# CITY OF ALBUQUERQUE

May 28, 2020

**Re: Lot 5 Meridian Business Park  
7501 Meridian Place NW, Ste B-2  
Traffic Circulation Layout  
Architect's Stamp 05-26-20(K10-D023G)**

5 BIKE POST DETAIL
1"=1'-0"

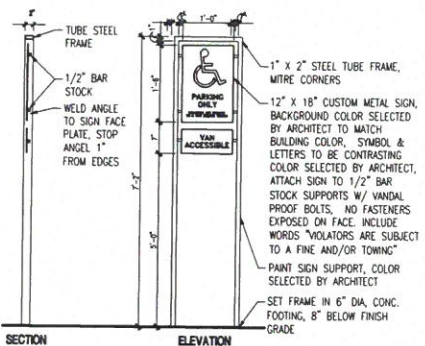
10. All bicycle racks shall be designed according to the following guidelines:
  - a. The rack shall be a minimum 30 inches tall and 18 inches wide.
  - b. The bicycle frame shall be supported horizontally at two or more places. Comb/toaster racks are not allowed.

- c. The rack shall be designed to support the bicycle in an upright position. See the IDO for additional information.
  - d. The rack allows varying bicycle frame sizes and styles to be attached.

- e. The user is not required to lift the bicycle onto the bicycle rack.
  - f. Each bicycle parking space is accessible without moving another bicycle.

11. Bicycle racks shall be sturdy and anchored to a concrete pad.
12. A 1-foot clear zone around the bicycle parking stall shall be provided.
13. Bicycle parking spaces shall be at least 6 feet long and 2 feet wide.

4 HANDICAP PARKING SIGN
1"=1'-0"

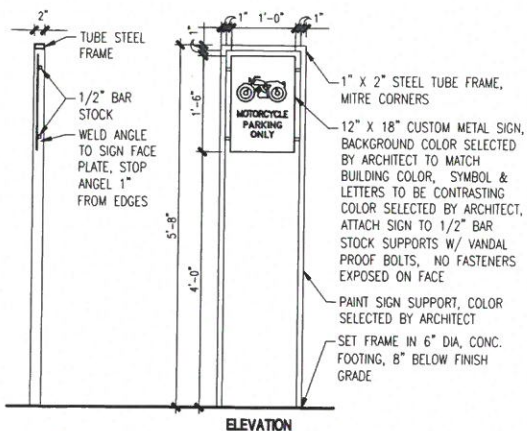
5. Label the compact parking spaces by placing the words "COMPACT" on the pavement of each space.
6. The ADA accessible spaces must include an access aisle. Van accessible aisles should be 8ft wide; all others should be 5ft wide.
7. The ADA accessible parking sign must have the required language per 66-7-352.4C NMSA 1978 **"Violators Are Subject to a Fine and/or Towing."** Please call out detail and location of signs.
8. ADA curb ramps must be updated to current standards and have truncated domes installed on Meridian Place entrances.

3 EXIST. MOTORCYCLE PARKING SIGN
1"=1'-0"

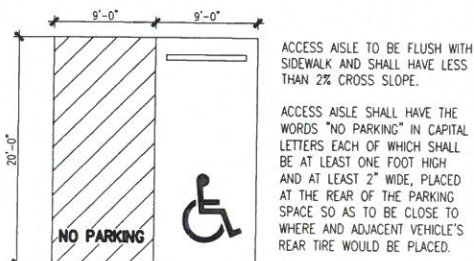
9. Motorcycle parking spaces shall be designated by its own conspicuously posted upright sign, either free-standing or wall mounted per the zoning code. Label pavement MC>

1 SITE PLAN
1"=30'

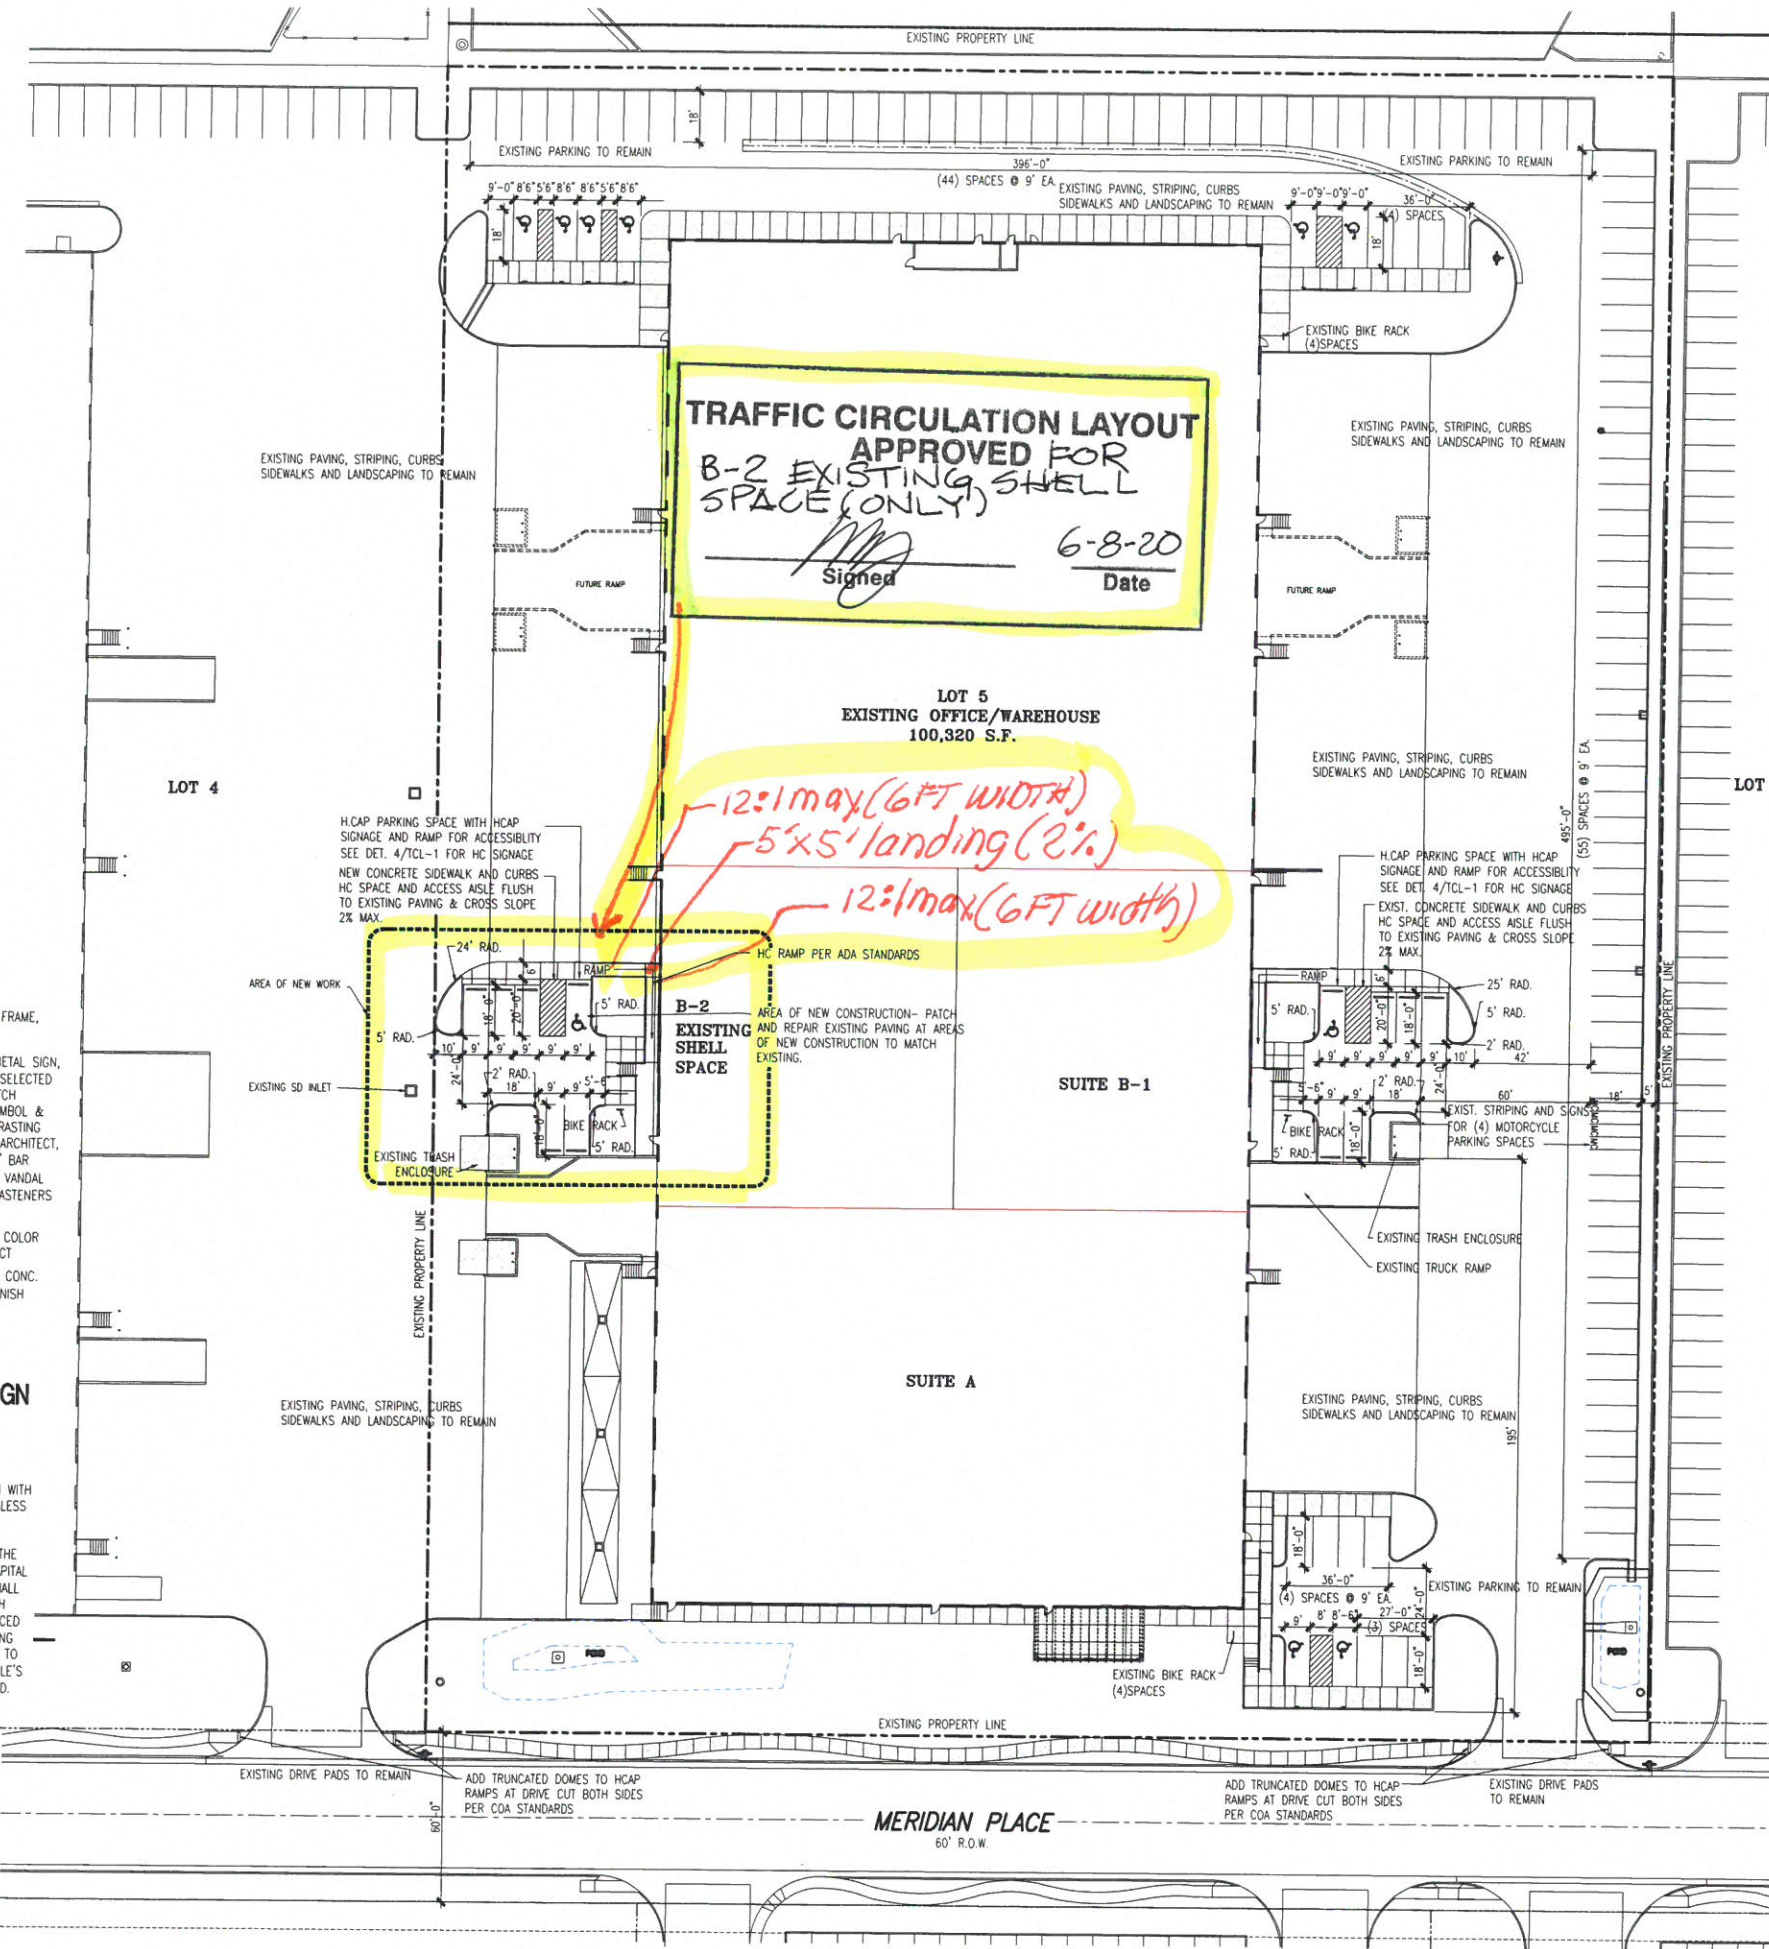
1. Please coordinate all calculations for parking spaces, including bicycle and motor cycle parking with Zoning and list the number required.
2. Identify all existing access easements and rights of way width dimensions.
3. Please list the width and length for all existing and proposed parking spaces. Some dimensions are not shown.
4. The minimum parking stall dimensions are:

14. Show all drive aisle widths and radii. Some dimensions are not shown.
15. The minimum drive aisle dimensions are shown below

16. List radii for all curves shown; for passenger vehicles. Radius for delivery trucks, fire trucks, etc. is 25 ft. or larger.
17. Per the IDO, a 6 ft. wide ADA accessible pedestrian pathway is required from the public sidewalk to the building entrances. Please clearly show this pathway and provide details.
18. Per DPM, a 6 ft. wide ADA accessible pedestrian pathway is required from the ADA parking stall access aisles to the building entrances. Please clearly show this pathway and provide details. This includes all ramp widths of ADA parking stalls.
19. Parking areas shall have barriers to prevent vehicles from extending over public sidewalk, public right-of-way, or abutting lots.
20. Provide a copy of refuse approval.

21. Please provide a sight distance exhibit
22. Show the clear sight triangle and add the following note to the plan:  
"Landscaping and signage will not interfere with clear sight requirements. Therefore, signs, walls, trees, and shrubbery between 3 and 8 feet tall (as measured from the gutter pan) will not be acceptable in the clear sight triangle."
23. Please specify the City Standard Drawing Number when applicable.
24. Shared Site access: driveways that straddle property lines, or are entirely on one property but are to be used by another property, shall have an access easement. Please include a copy of your shared access agreement with the adjacent property owner.

Type of parking	Min. Width	Min. Length	Min. Overhang
<b>Standard</b>	<b>8.5'</b>	<b>18'</b>	<b>2'</b>
<b>Compact</b>	<b>7.5'</b>	<b>15'</b>	<b>1.5'</b>
<b>Motorcycle</b>	<b>4'</b>	<b>8'</b>	<b>N/A</b>
<b>ADA</b>	<b>8.5'</b>	<b>18'</b>	<b>2'</b>

Minimum Drive Aisle Width
Two Way Traffic	22'
Main Circulation Road	24'
<b>Fire Lane</b>	<b>20'</b>
